KITTITAS COUNTY COMMUNITY DEVELOPMENT SERVICES

January 9, 2007

RE: Koren Short Plat (SP-06-70) (re-issue)

KOREN SHORT PLAT
PART OF SECTIONS 8 AND 9, T. 19 N., R. 15 E., W.M.
KITITAS COUNTY, WASHINGTON

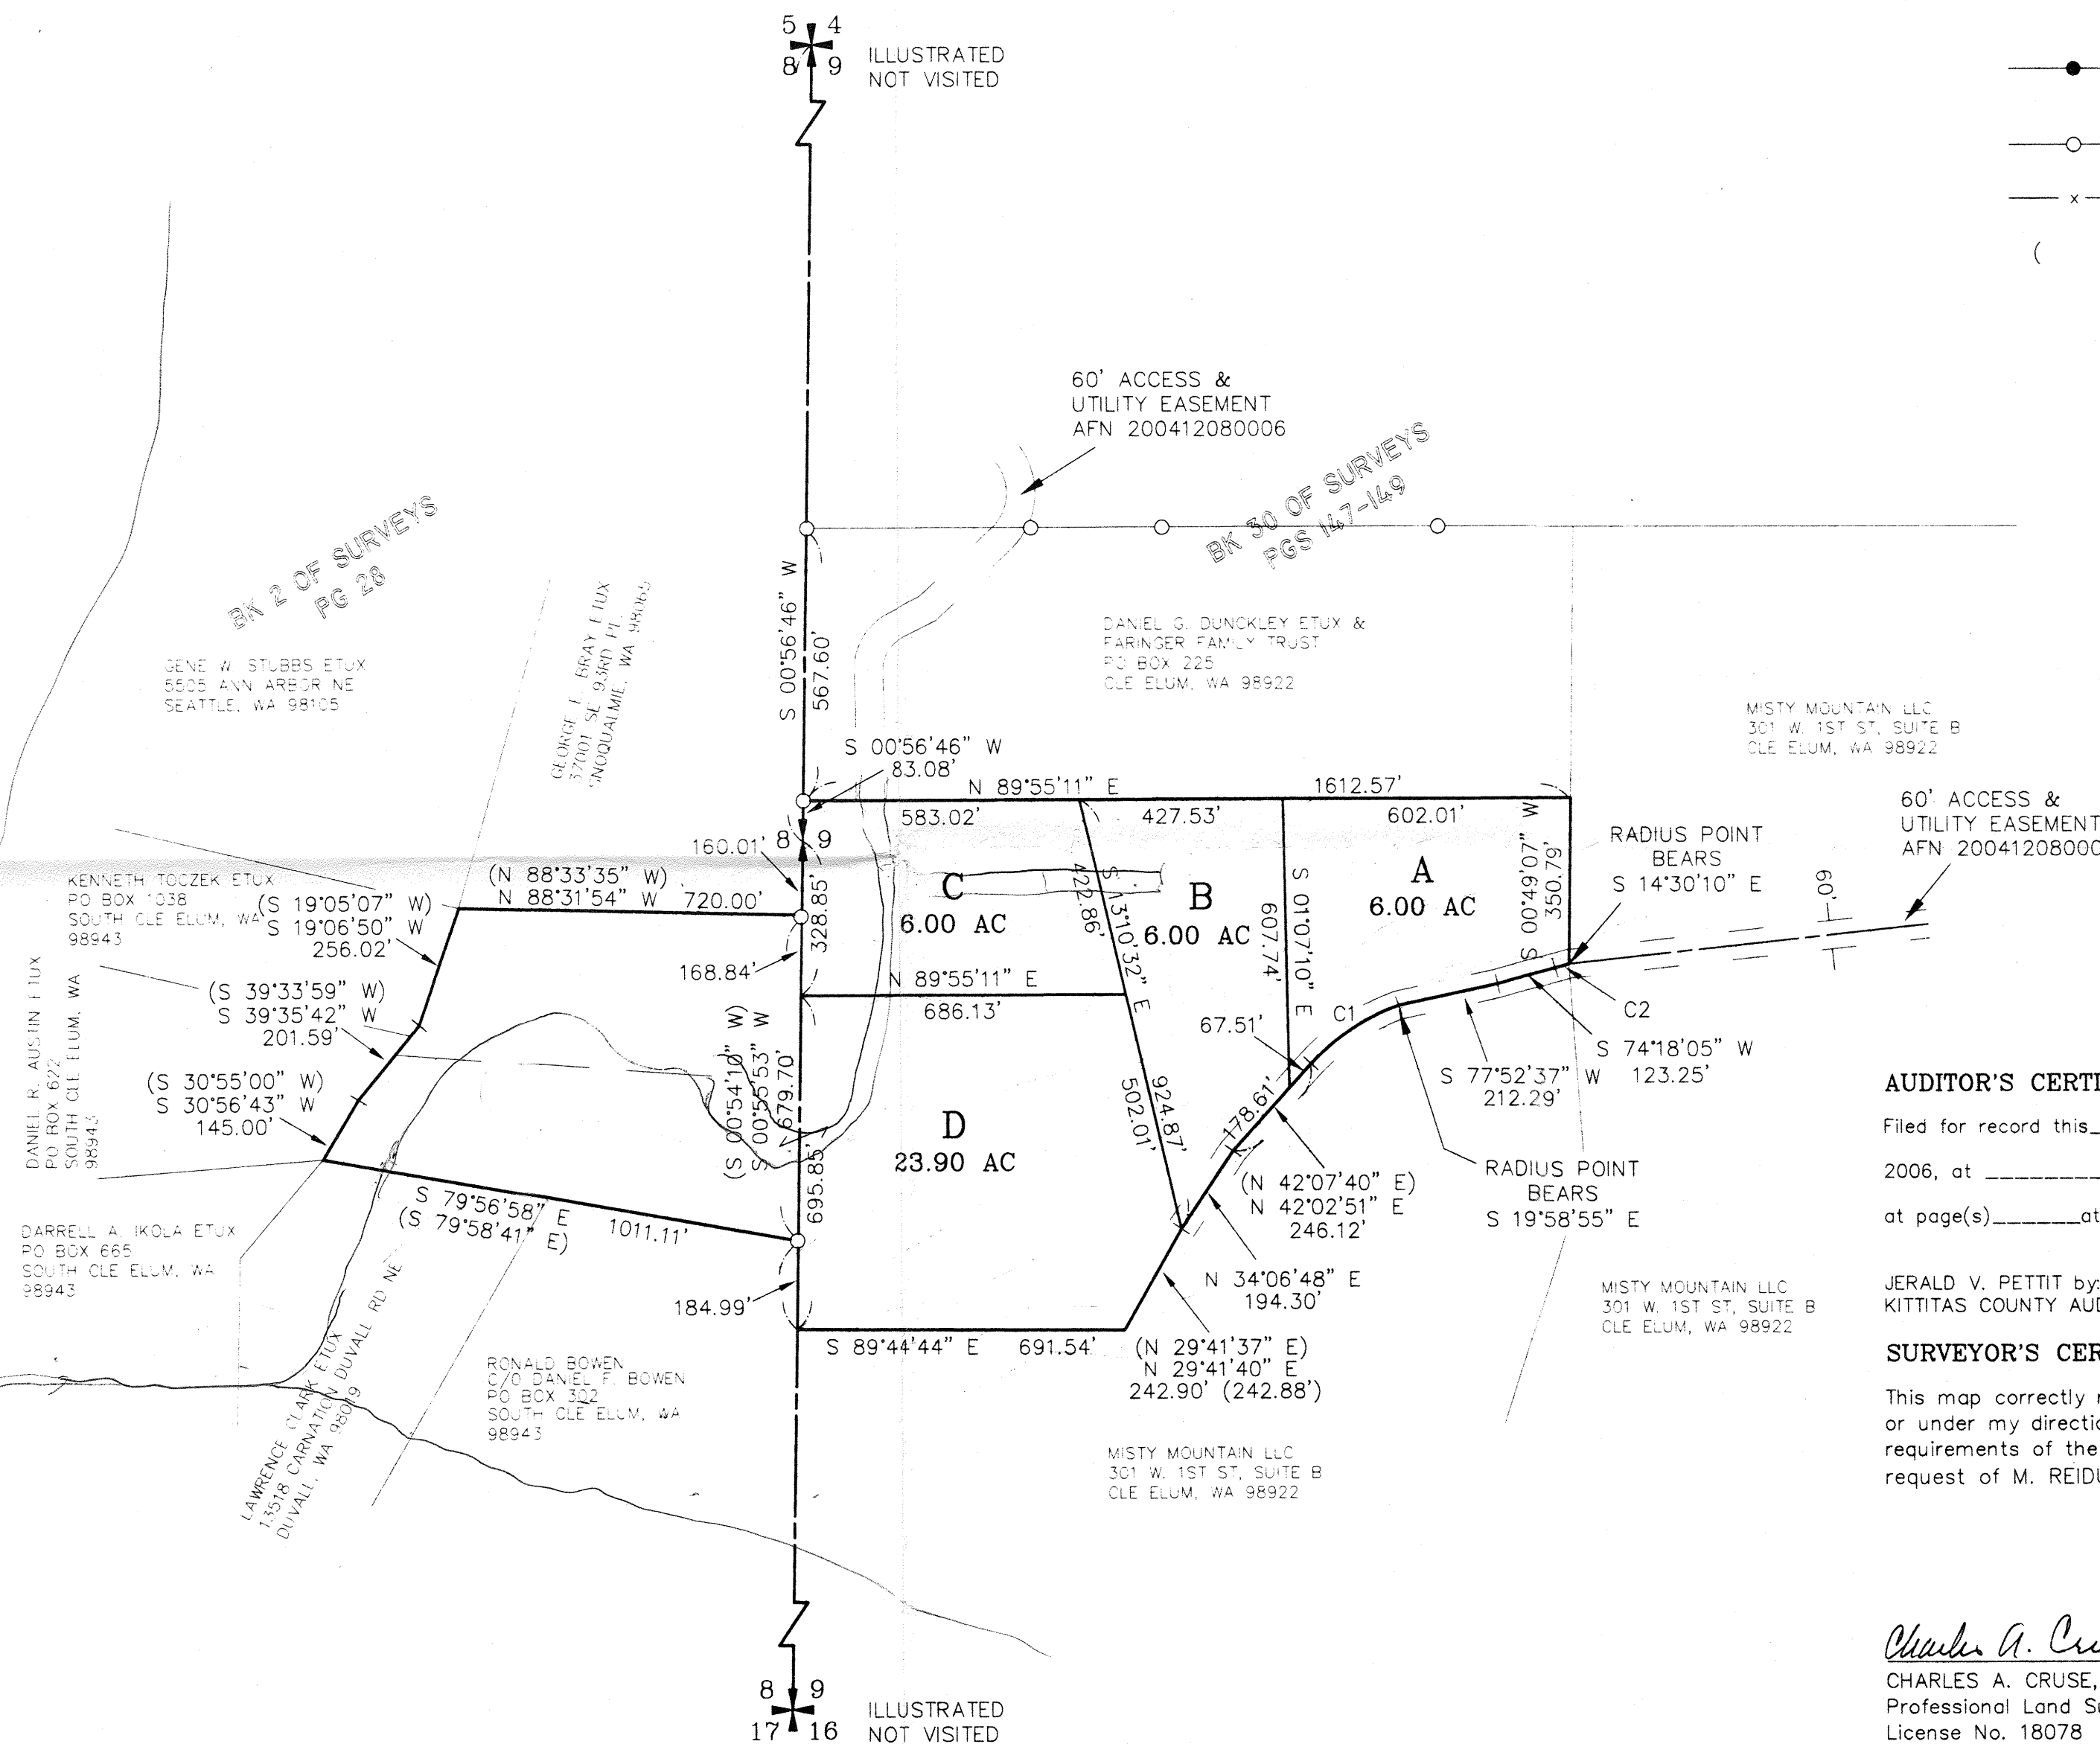
1. Both sheets shall reflect the short plat number SP-06-70.
2. Please contact Randy Carbary at 962-7019, Kittitas County Public Works, regarding all road standards and access questions.
3. Any further subdivision, regardless of exemption, shall be subject to SEPA review.
4. An additional condition from Kittitas County Public Works has been enclosed in this packet.
5. Attached you will find comments from Kittitas County Environmental Health and Kittitas County Public Works. **Please see those documents for required plat notes and information on issues needing completion before final approval of this short plat.**
